City of Albuquerque

September 30, 1999

**RE: STEWART DEVELOPMENT (J14-D131). ENGINEER'S CERTIFICATION
FOR CERTIFICATE OF OCCUPANCY APPROVAL. ENGINEER'S STAMP
DATED SEPTEMBER 3, 1999.**

GRADING AND DRAINAGE PLAN CERTIFICATION:

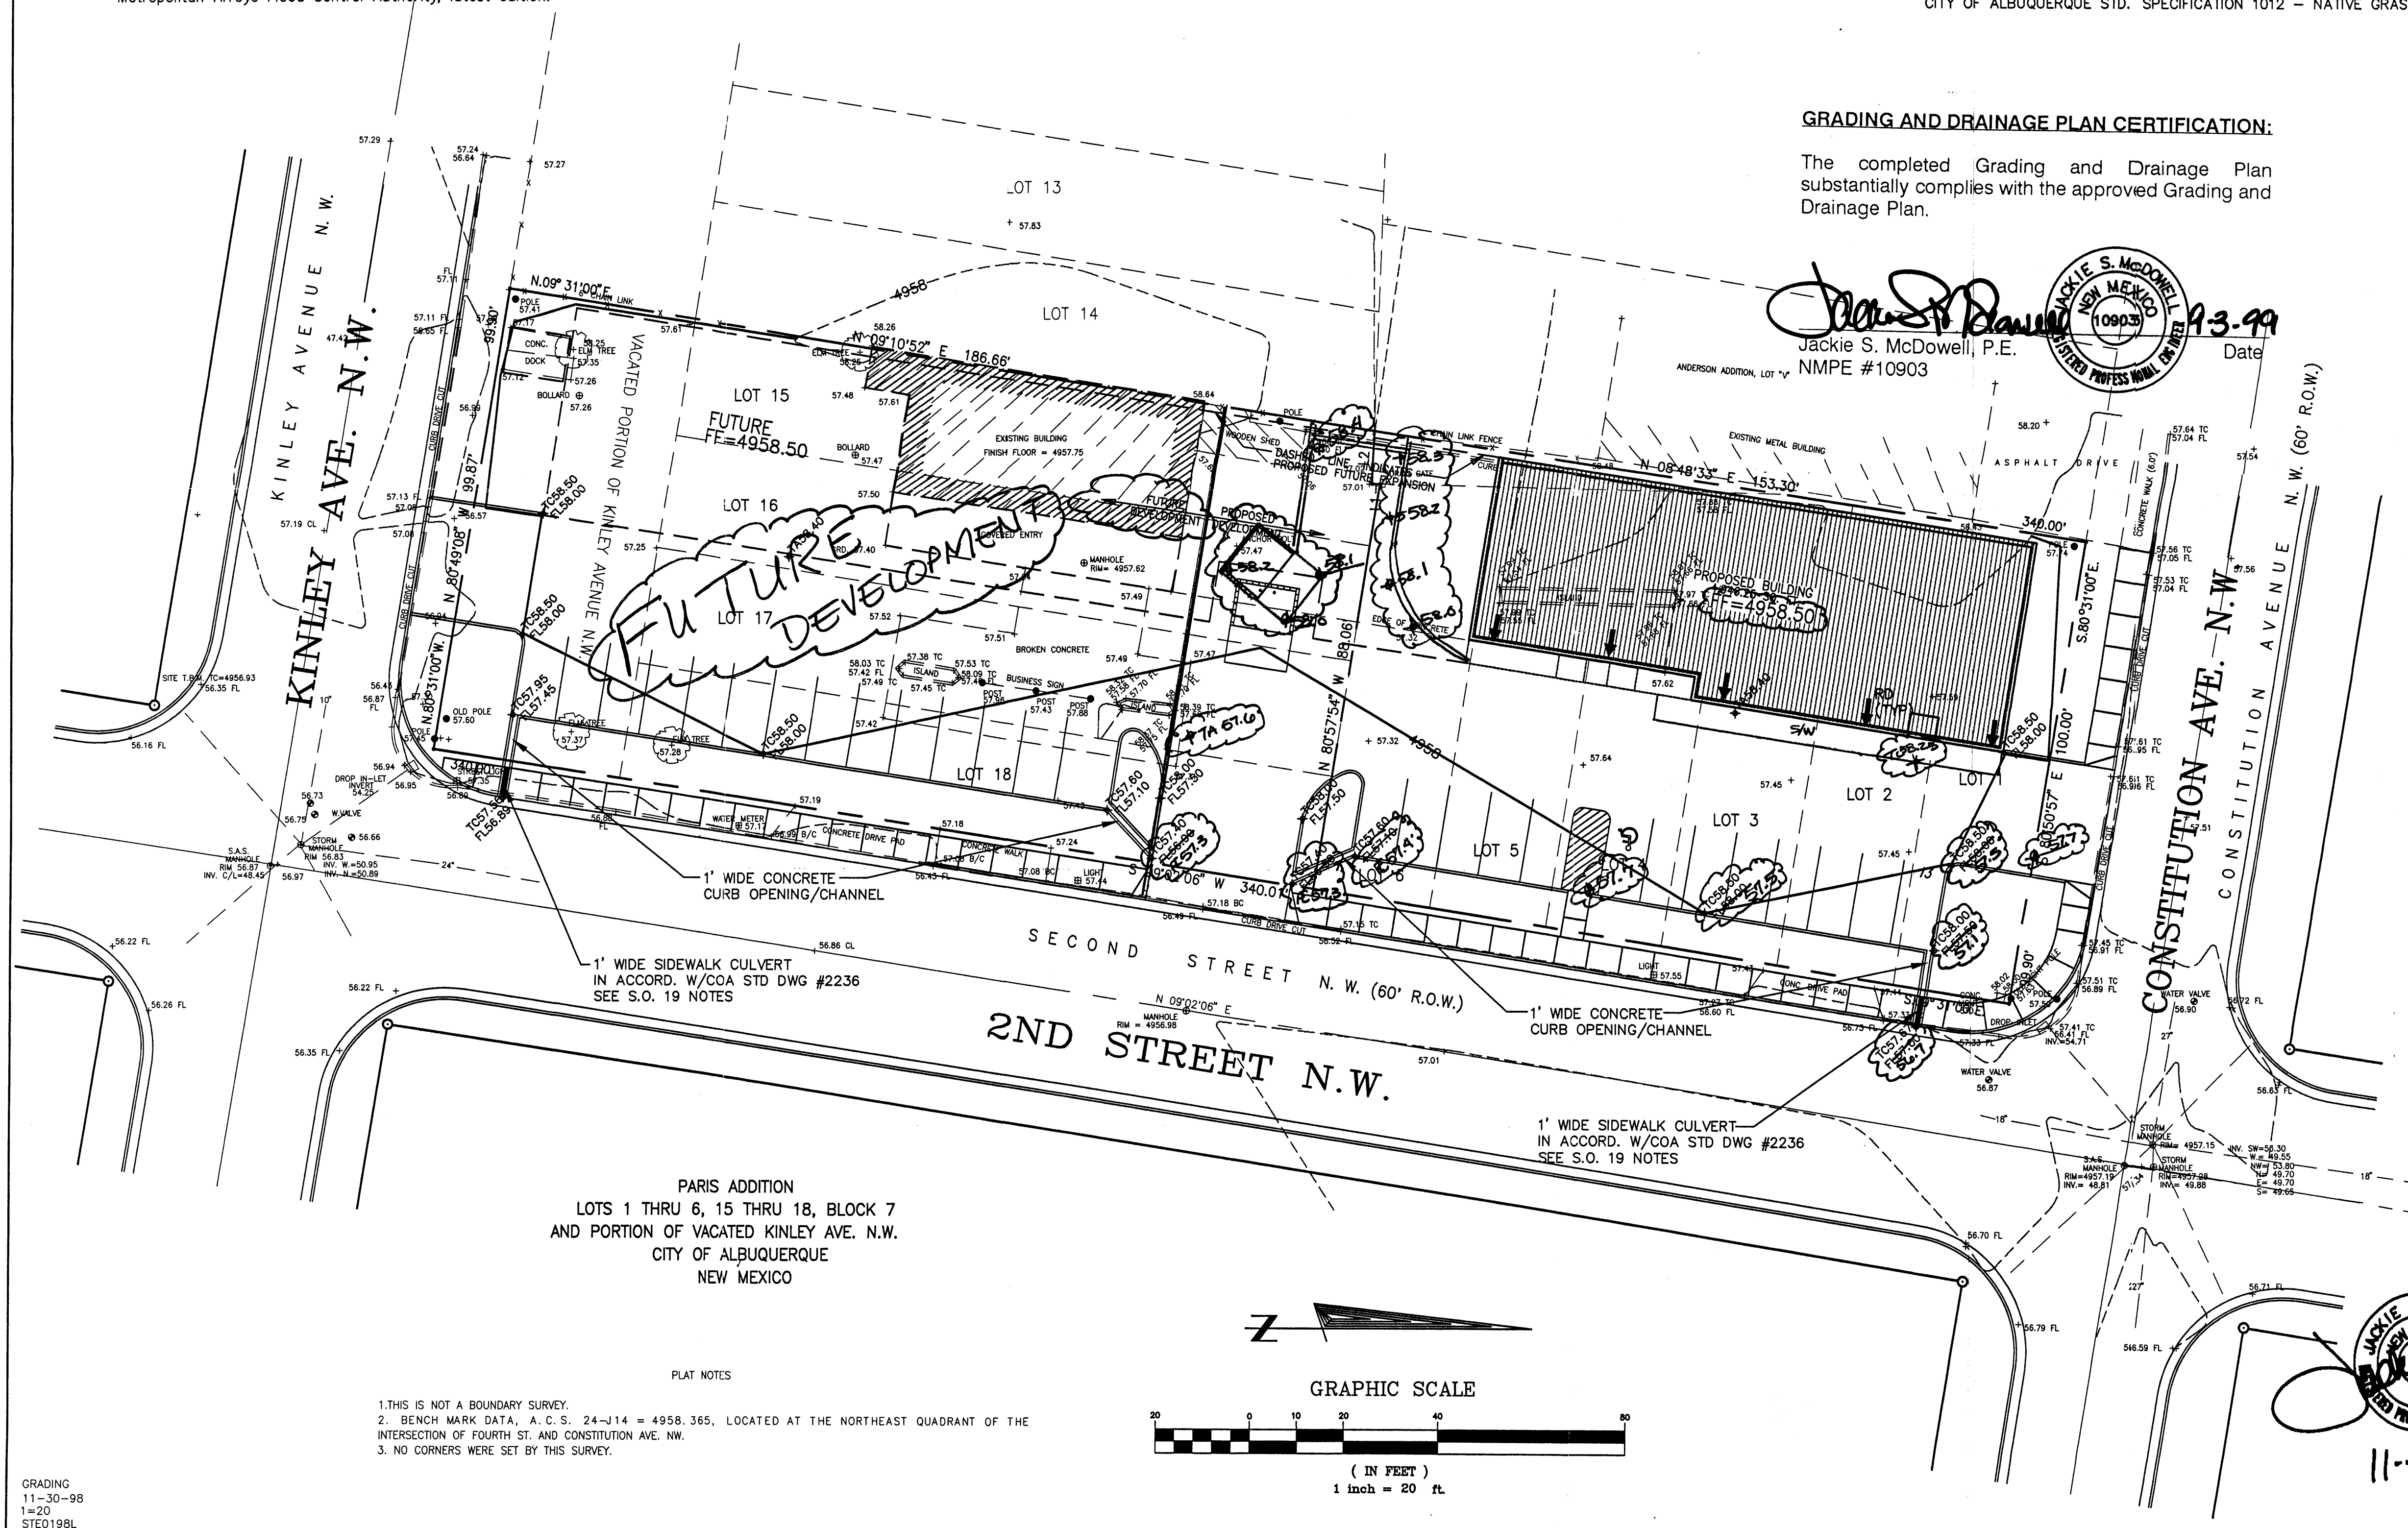
Based on the information provided on your September 3, 1999 submittal, the above referenced project is approved **CONDITIONALLY** for Certificate of Occupancy. Please complete the SO#19 Signature Block - sidewalk culvert at 2nd & Constitution - for the Record Drawings.
